**St MATTHEWS CATHOLIC COLLEGE, MUDGEES (SSD 9872)
CORNER BROADHEAD ROAD AND BRUCE ROAD, SPRING FLAT (MUDGEES)
RESPONSE TO SUBMISSIONS**

RESPONSE TO DPIE KEY ISSUES AND AGENCY, COUNCIL & PUBLIC SUBMISSIONS

**VEHICLE SIMULATION NOTES:**

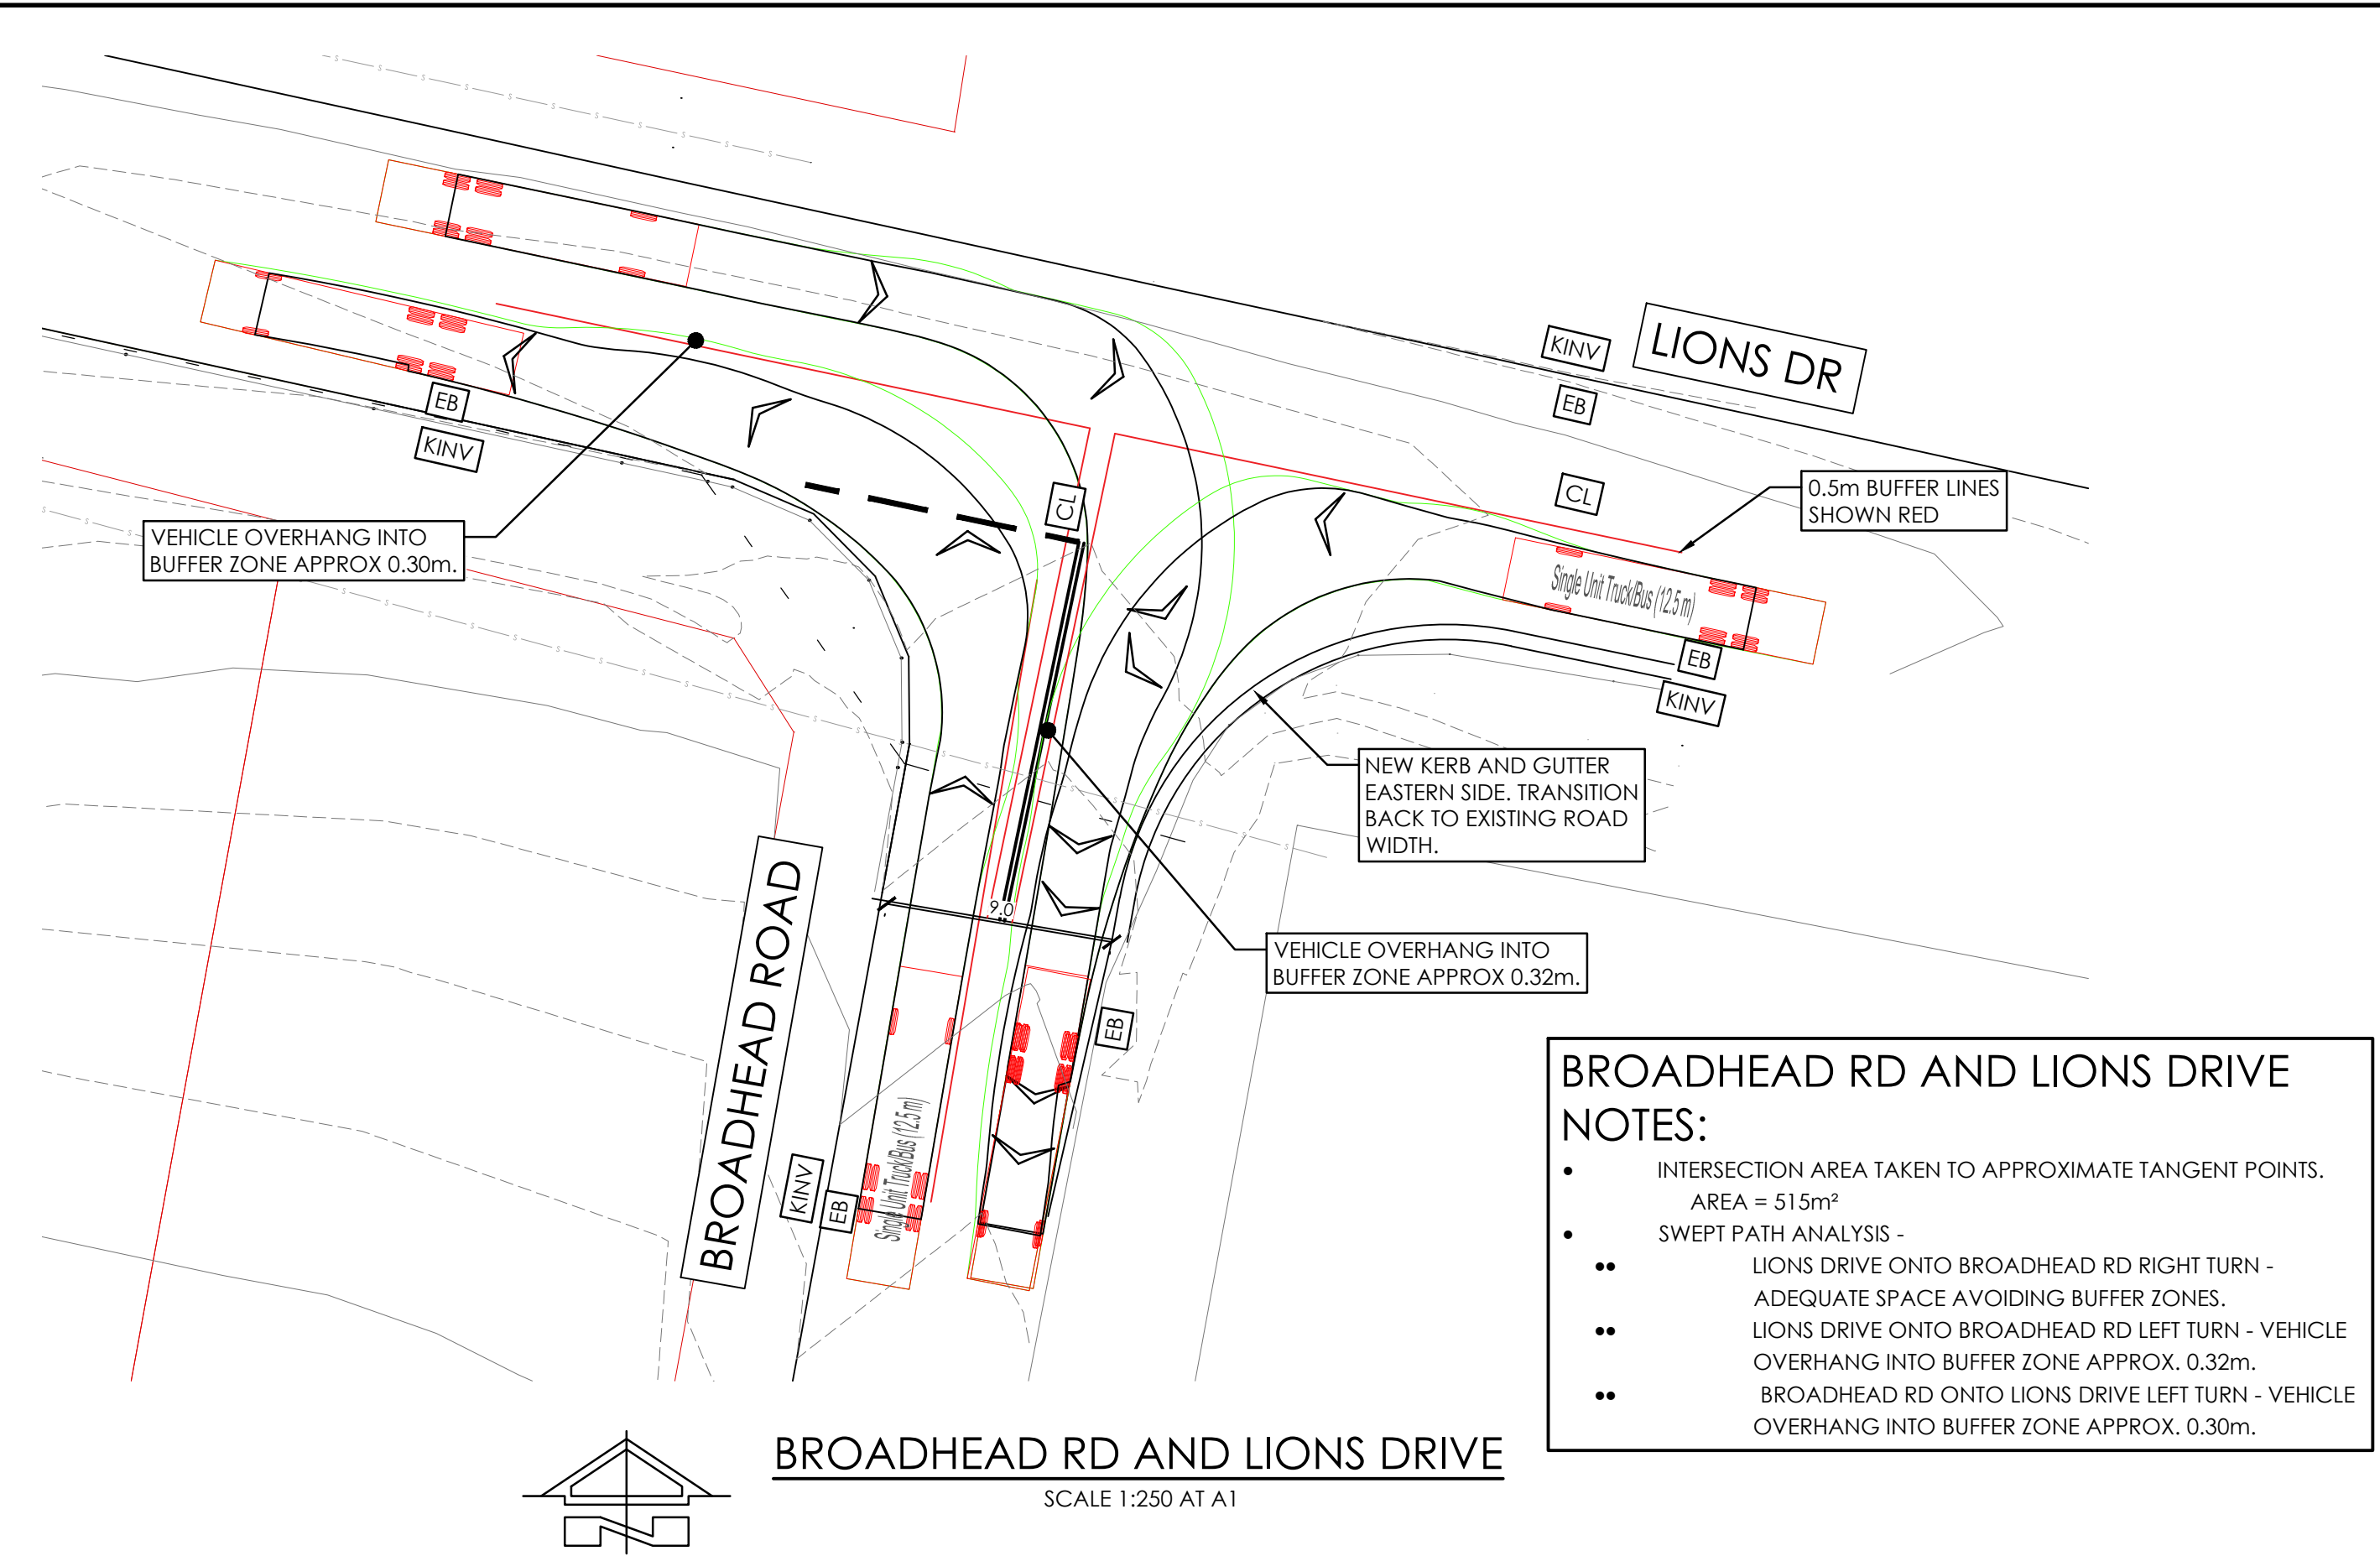
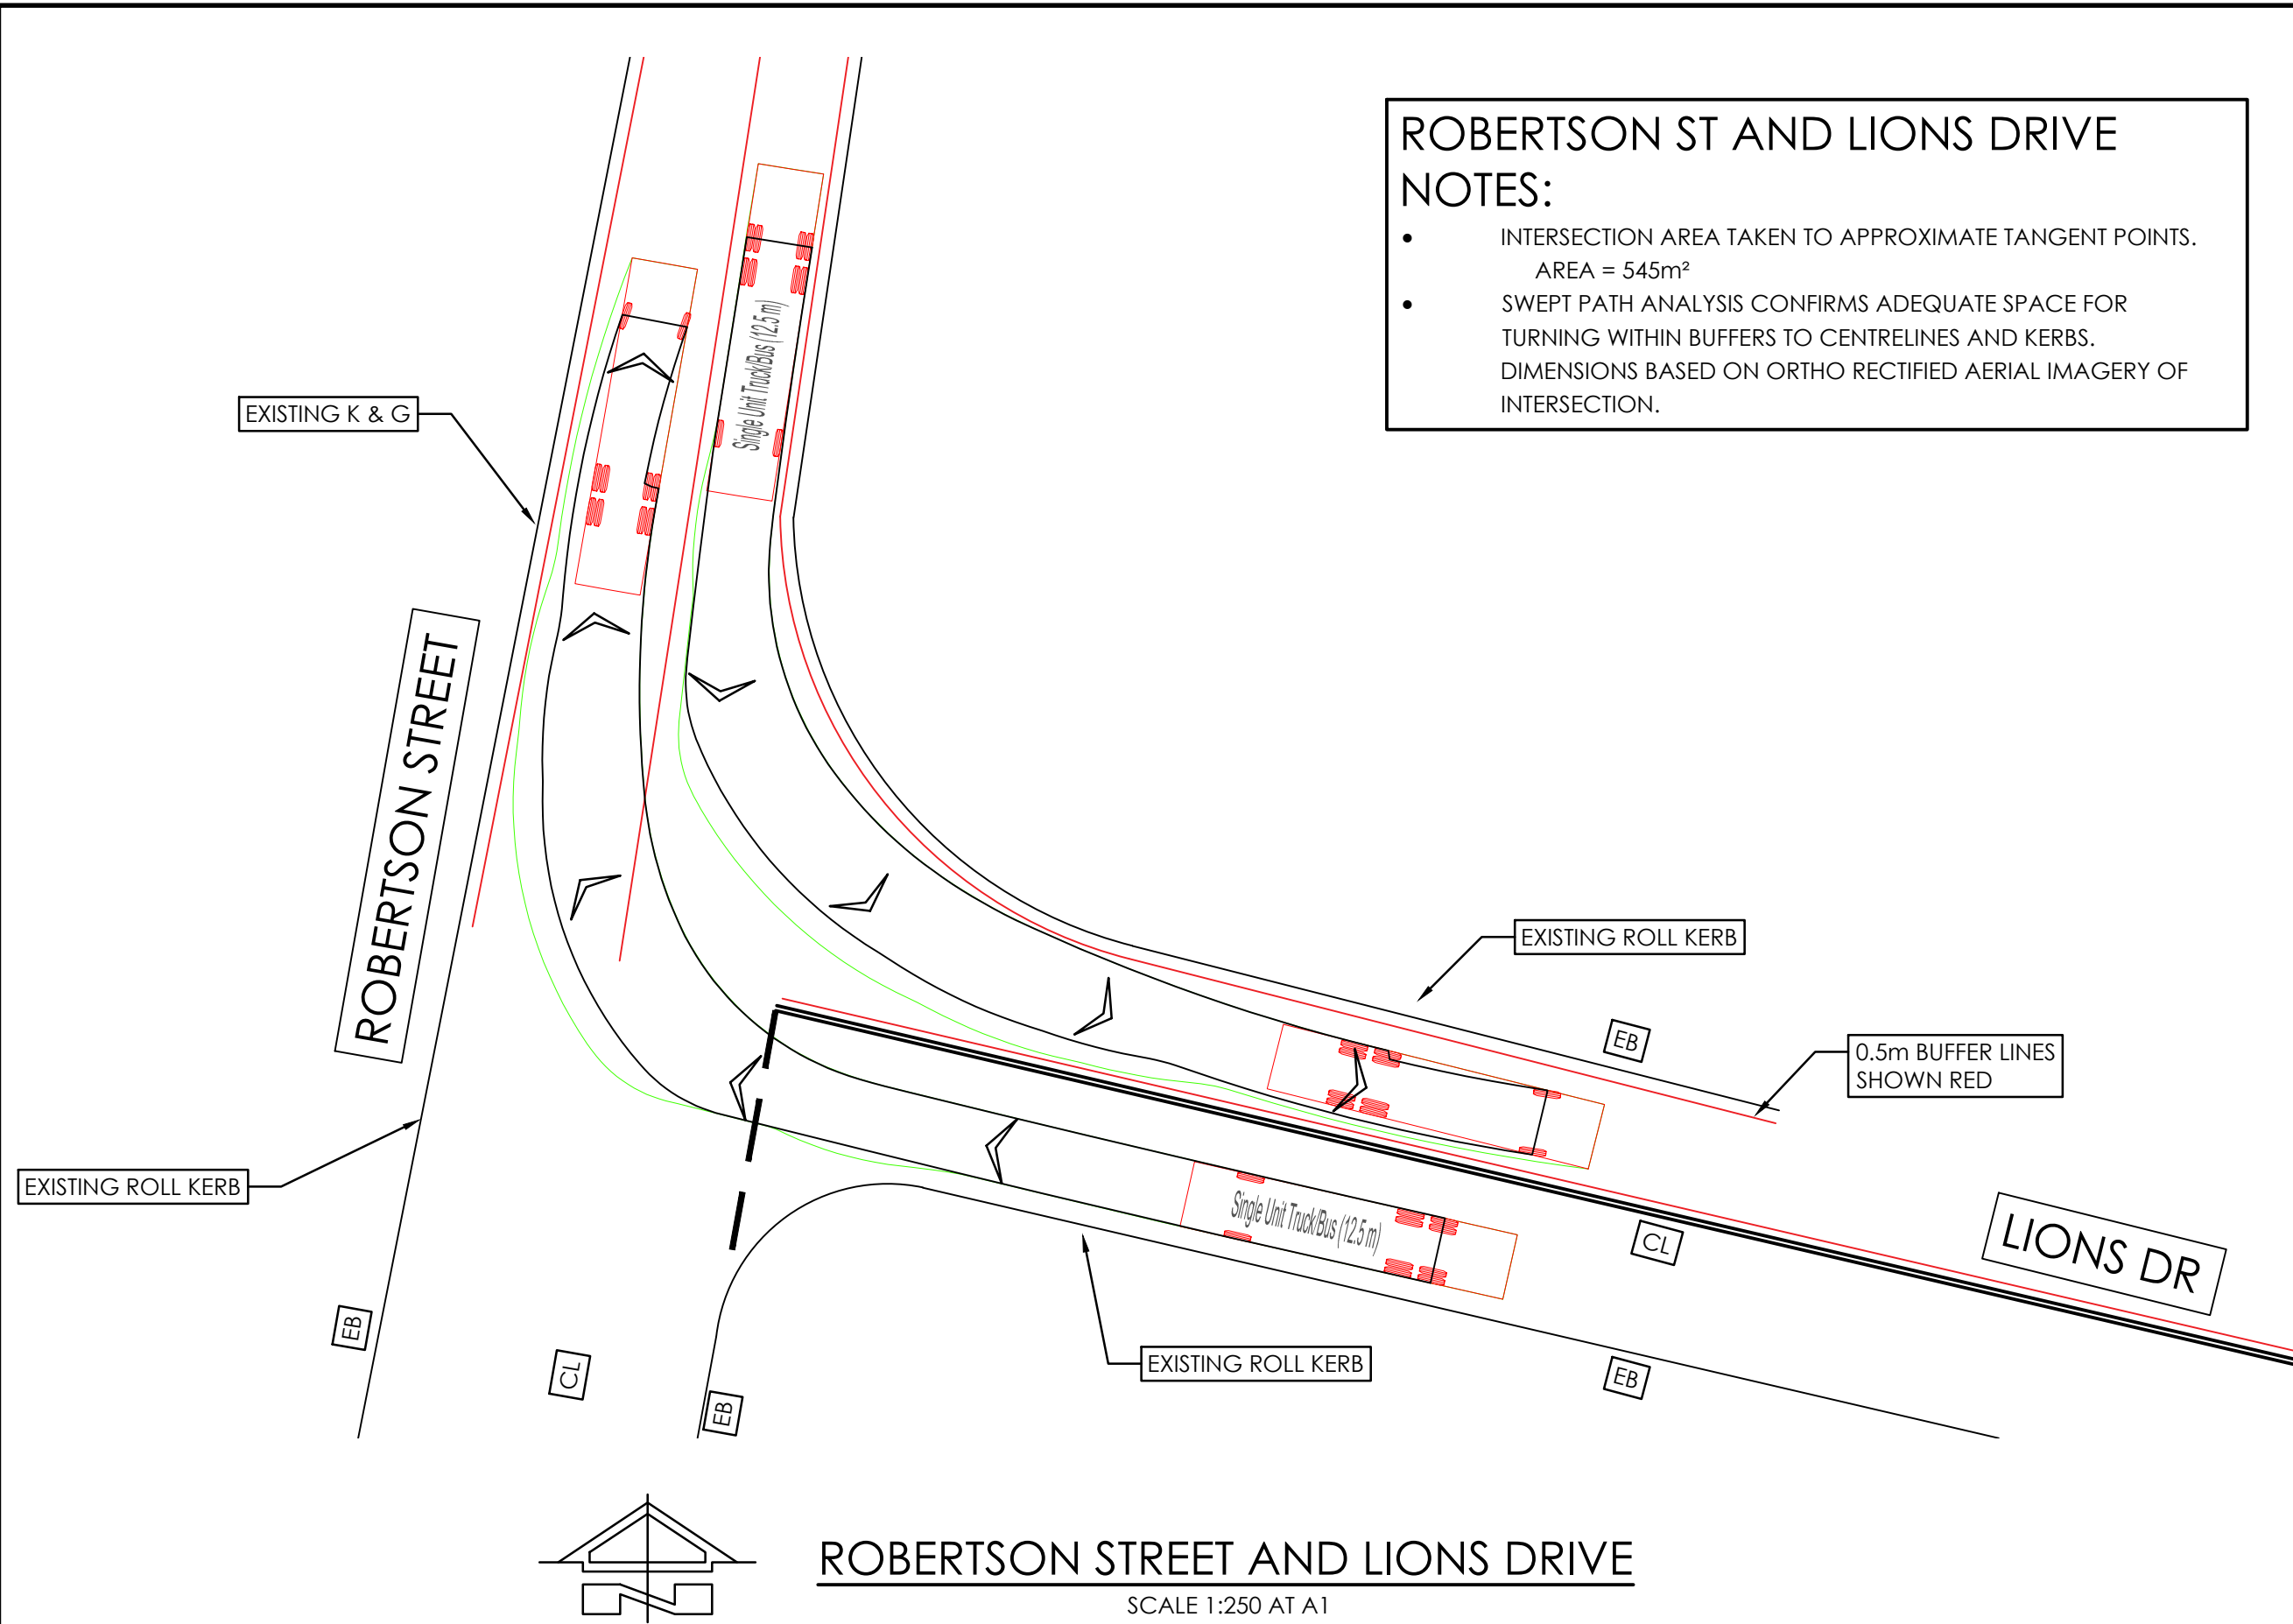
<p>(e) It is not clear from the information provided that buses turning left out of Broadhead Road into Bruce Road can undertake the turn movement in a lane correct manner. Swept path plans are required to demonstrate that turn movements are achievable in a lane correct manner. If the turn movements cannot be made within the correct lanes, an upgrade to the intersection to accommodate the turning movements is required.</p>	<p>A further swept path analysis has been undertaken by Triaxial of the bus turning movement left out of Broadhead Road into Bruce Road in a lane correct manner. The swept path analysis shows that the left-turn movement can be sufficiently accommodated within the traffic lanes without impacting the westbound traffic lane on Bruce Road. Similarly, the opposite movement has also been provided.</p> <p>The swept path plan showing this (and other) manoeuvres is provided in Appendix H.</p>
